Sent: 11 March 2014 11:02
To: Janice Chapman
Subject: Extension Application No: EG/5/14

Further to our meeting this morning, I am writing to express my own comments, and that of my wife's, regarding the proposed extension to No. 49 Elm Grove, Barnham.

For the sake of simplicity, I will confine these to comments in relation to Policy D DM4: Extensions and Alterations to Existing Buildings (residential and non-residential - ref 13.4.6 local plan).

Drawing Title:
Elevations and General Section

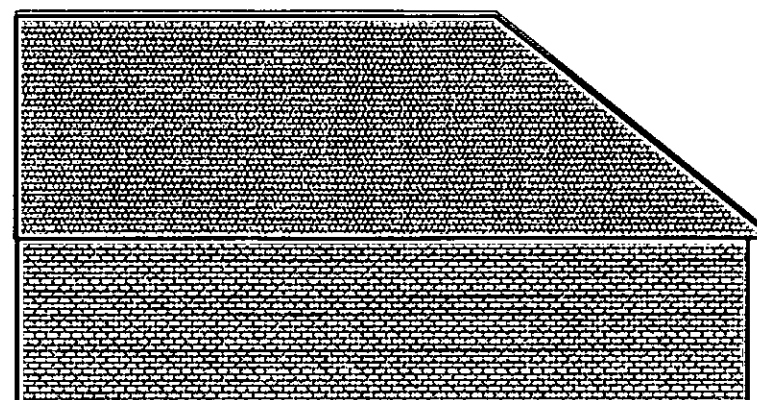
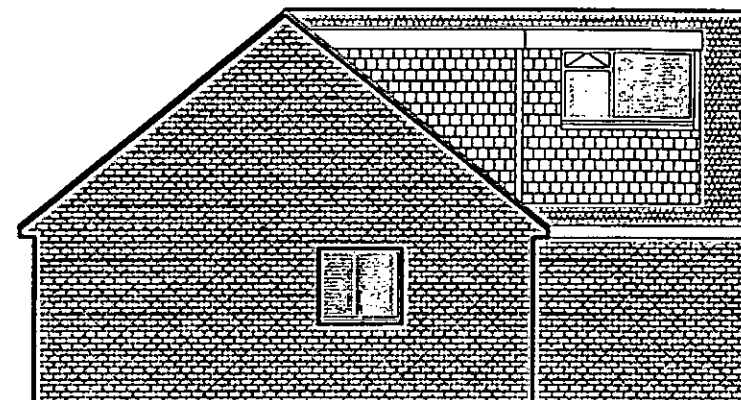
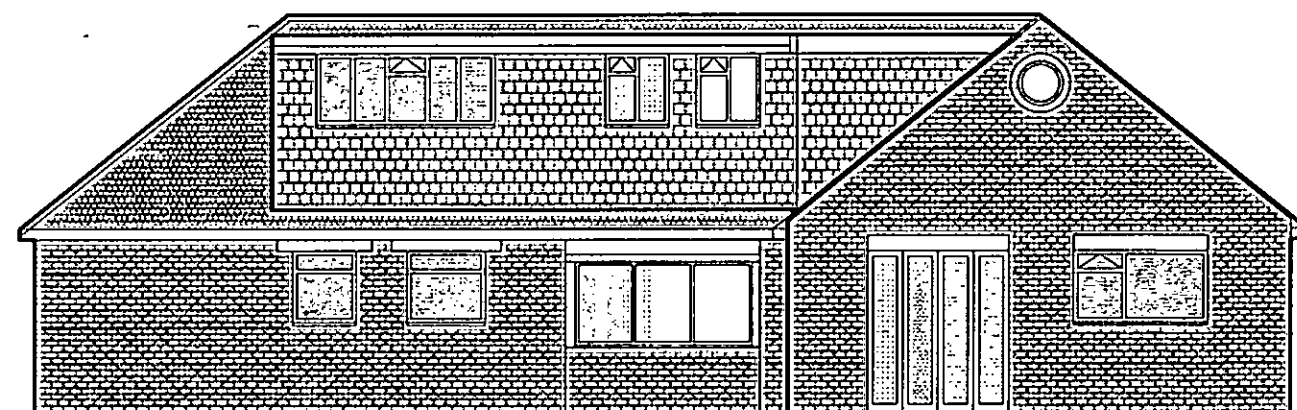
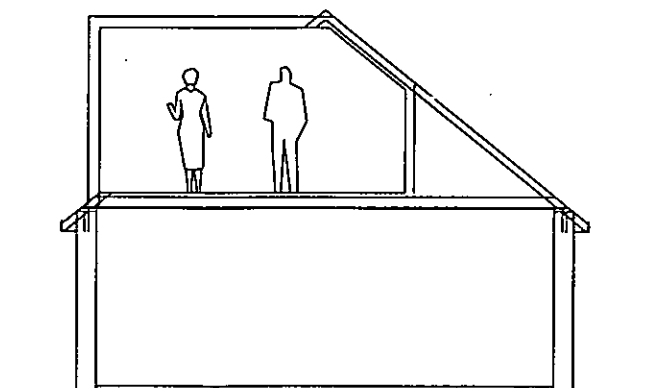
a. the extension or alteration sympathetically relates to and is visually integrated with, the existing building in siting, massing, design, form, scale and materials: visually the change from sloped roof bungalow to 2 storey, flat roof elevation at the rear is not integrated. The massing and scale from the elevations presented to this neighbouring property represent very substantial changes (eg. roof surface on view x 2.5, height of structure doubled at rear extension).

b. the extension or alteration is visually subservient to the main building (...): clearly this is not the case from the rear and side elevation.

c. the extension or alteration does not have an adverse overshadowing, overlooking or overbearing effect on neighbouring properties: on all three counts, overshadowing, overlooking and overbearing, there are significant issues affecting this neighbouring property. Early to mid morning sunlight is reduced to the main reception rooms and bedrooms of 48 Elm Grove, which is a double fronted property, the front door being directly opposite the proposed development, and at approximately 9 metres' distance, including the 1 metre gap beyond the boundary line. The two storey rear elevation overlooks, and being so close is overbearing on, our garden's appearance and use.

e. the extension or alteration does not compromise the established spatial character and pattern of the place but is instead a positive addition: visually and otherwise, and for the reasons given above, it would not be a 'positive' addition. The addition is negative from the perspective of this property, and perhaps also, it could be argued, detracts from the 'spatial character' of the existing site.

Whilst we understand our neighbour's wish to extend her property, we believe that a more sympathetic proposal could have been drawn up, and matters such as placement of the new kitchen and upper storey bedroom need not necessarily have been sited as proposed, so close to our property line. Equally, the questions of roof line, rear elevations, scale, etc. could have been addressed more sympathetically. We
